1st floor extension to front elevation, proposed porch.

8 The Midway Felpham

Felpham Parish Council Object to the application on the grounds:

FRONT ELEVATION PROPOSED 1:100

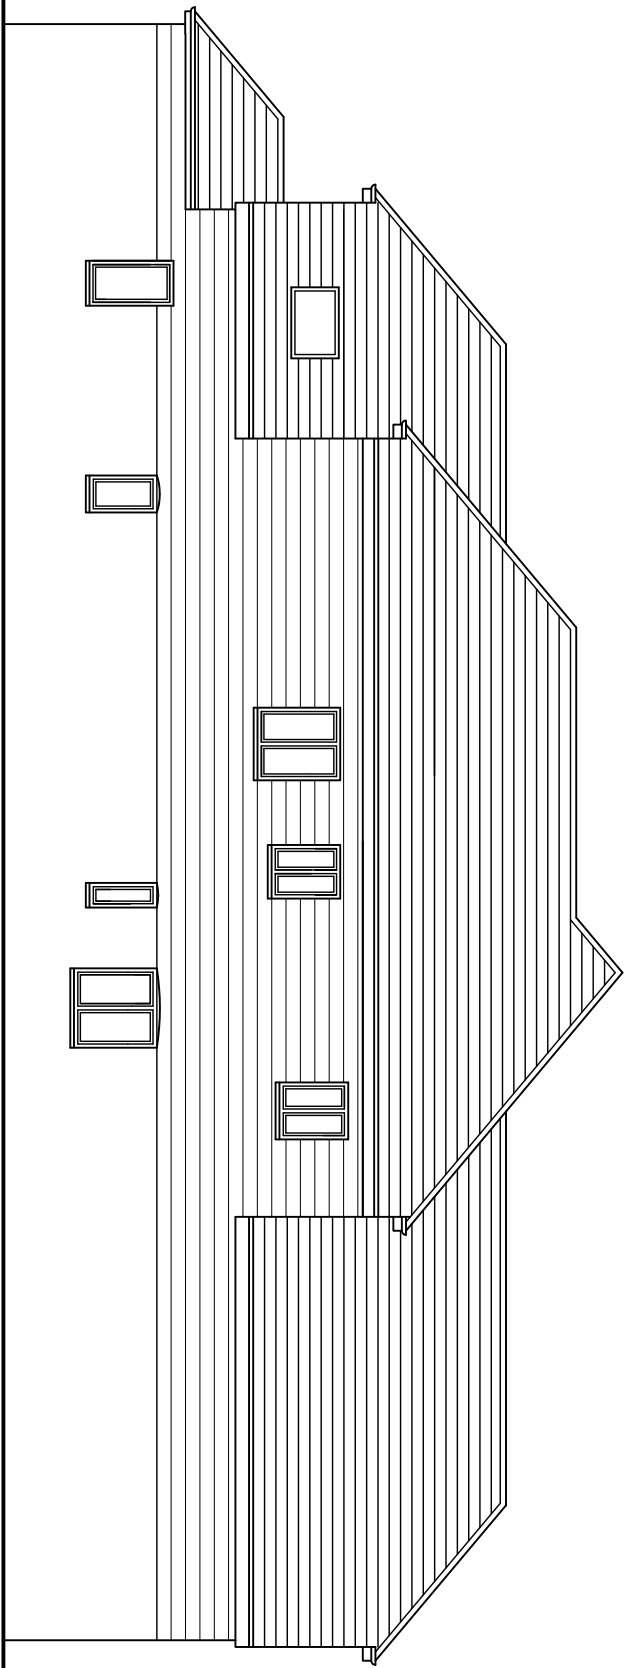
1) that the porch is not in keeping with the current street scene.
